Final Report - Corrections Required **Application No. ANEX-24-0006**

Description : Matrix Design Group on behalf of Colorado Springs Equities LLC is submitting a serial annexation petition for seven parcels and Land Use Plan/Rezoning exhibit for a portion of the subdivision known as Rock Creek Mesa.

Document Filename : 224.023-SURV-RCM ANNEX PLAT 6.pdf

ROCK CREEK MESA ADDITION NO. 6

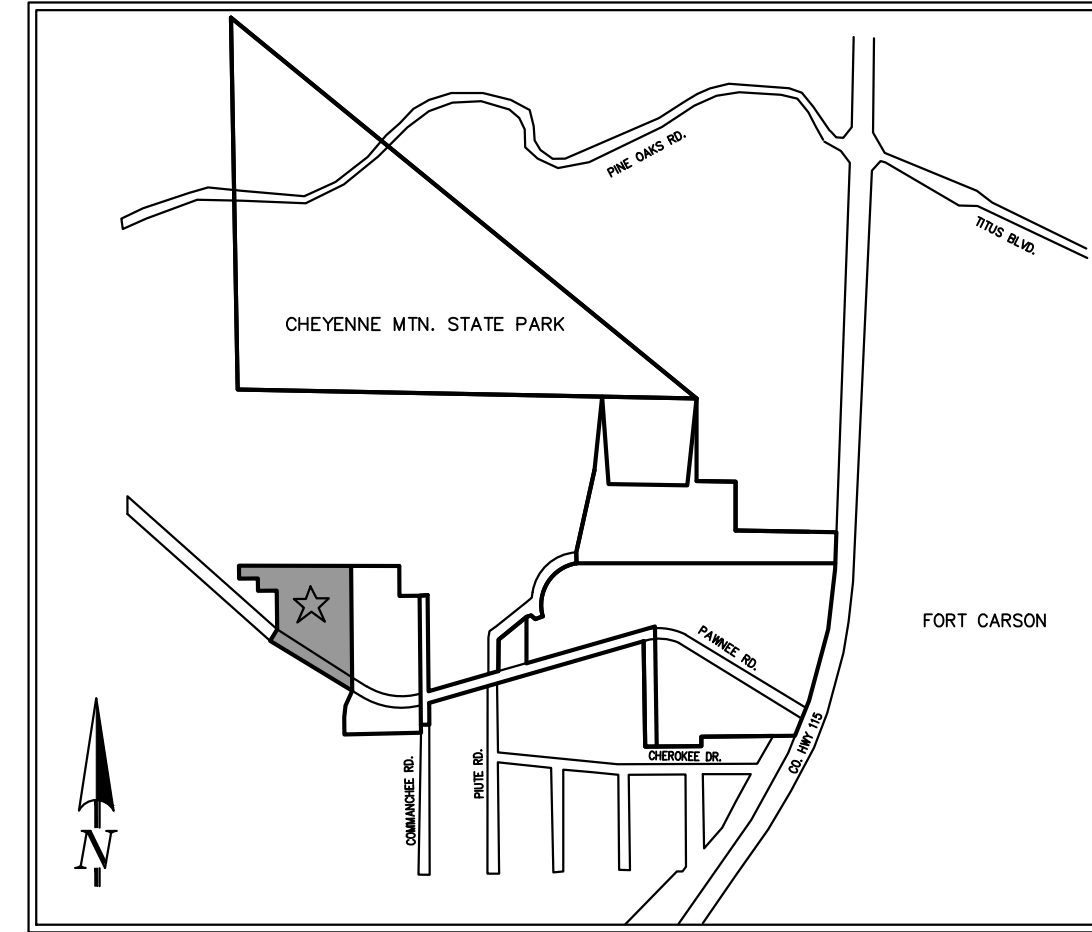
14	224.023-SURV-RCM ANNEX PLAT 6-TITLE	Sara Rivera : City Engineering - SWENT	The FEMA floodplain zone is incorrect. Please update to the correct zone.
2	224.023-SURV-RCM ANNEX PLAT 6-TITLE	Matthew Alcuran : Col Springs Utilities	<p>Please acknowledge the following Water Planning Informational Note: Please refer to the completed Hydraulic Analysis Report completed on November 2, 2023 for HR Green and SSS Education. Conclusions and Requirements: **Modeled fire flows are 2100 to 2200 GPM. No fire flow requirement was provided. **Either alternative presented in this report are acceptable. **Since all pressures are below 170 psi, PVC is acceptable.</p>
3		Matthew Alcuran : Col Springs	Utility Comments (electric, gas, water, wastewater)

Comment ID	Page Reference	Reviewer : Department	Review Comments
8	224.023-SURV-RCM ANNEX PLAT 6-TITLE	Matthew Alcuran : Col Springs Utilities	Please respond to CSU LBS comments: Have reviewed and entered geometry into FIMS. "Please add detail to the Point of Beginning, such as 'the most northerly corner on the most easterly line of said parcel'." "The first course references 'said Commanche Rd' when not referenced earlier."
15	224.023-SURV-RCM ANNEX PLAT 6-TITLE	Gabe Sevigny : Planning	Update ANEX-24-0006 on each sheet
19	224.023-SURV-RCM ANNEX PLAT 6-TITLE	Cory Sharp : Planning	Please update 3, 4 & 5 to the following contiguity statement: contiguity statement: Total Perimeter of the Area for Annexation: 2,610.45' One-Fourth (1/4th) of the Total Perimeter: 652.61' (25.00%) Perimeter of the Area Contiguous to the Existing City Limits: 726.09' (27.81%)
22	224.023-SURV-RCM ANNEX PLAT 6-TITLE	Cory Sharp : Planning	Please add quotations around the plat name "Rock Creek Mesa Addition No. 6"

23	224.023-SURV-RCM ANNEX PLAT 6-TITLE	Cory Sharp : Planning	Please add the area at the end of the legal description
24	224.023-SURV-RCM ANNEX PLAT 6-GRAPHIC 1	Cory Sharp : Planning	Please depict and label the basis of bearings and add tie to point of beginning so all additions can be tied together
25	224.023-SURV-RCM ANNEX PLAT 6-GRAPHIC 1	Cory Sharp : Planning	Please remove Rock Creek Mesa Addition No. 6
26	224.023-SURV-RCM ANNEX PLAT 6-GRAPHIC 1	Cory Sharp : Planning	It would be helpful to change the text style of ownership information so that it is clearly informational text
27	224.023-SURV-RCM ANNEX PLAT 6-GRAPHIC 1	Cory Sharp : Planning	Please add (M) and (C) to the legend
28	224.023-SURV-RCM ANNEX PLAT 6-GRAPHIC 1	Cory Sharp : Planning	Please remove the areas from all adjacent parcels
29	224.023-SURV-RCM ANNEX PLAT 6-GRAPHIC 1	Cory Sharp : Planning	Please clearly depict all of the city limits not just that adjacent portion

ROCK CREEK MESA ADDITION NO. 6

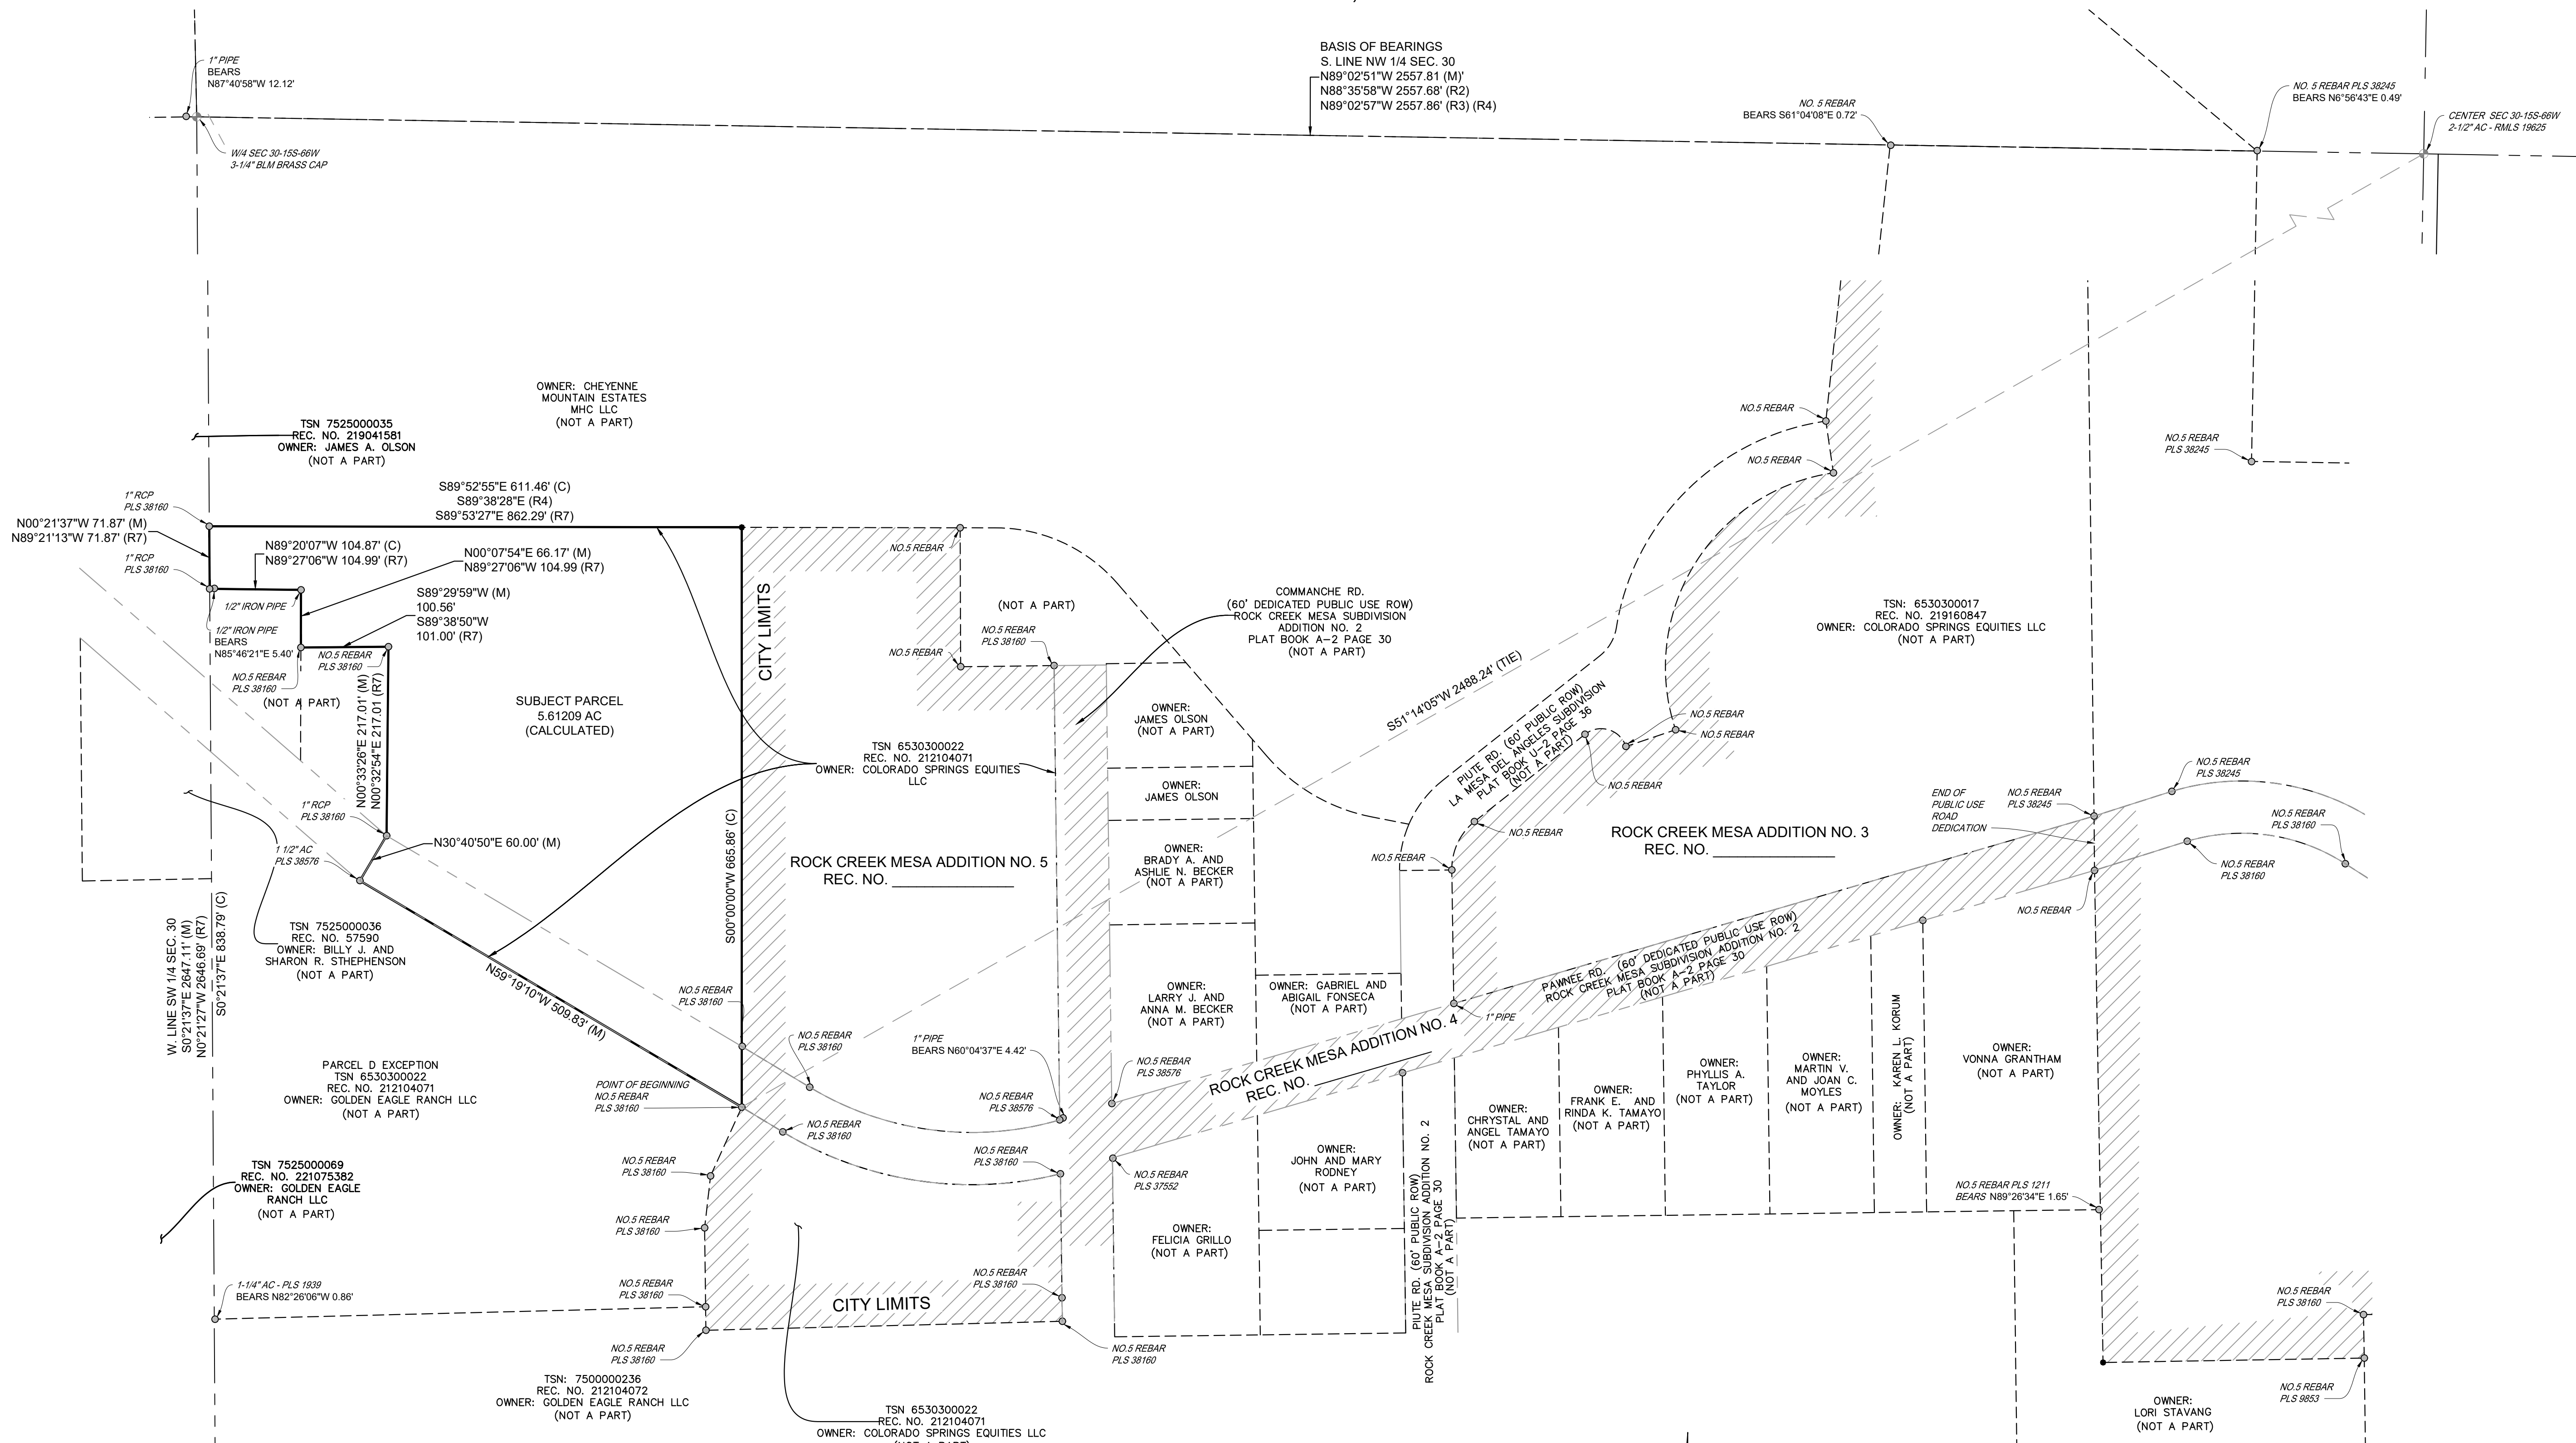
30	224.023-SURV-RCM ANNEX PLAT 6-GRAPHIC 1	Cory Sharp : Planning	Please clearly label the adjacent areas *not a part* for clarity

Comment ID	Page Reference	Reviewer : Department	Review Comments
31	224.023-SURV-RCM ANNEX PLAT 6-GRAPHIC 1	Cory Sharp : Planning	It would be easier for review if the adjacent areas were a dashed line type please review and adjust accordingly
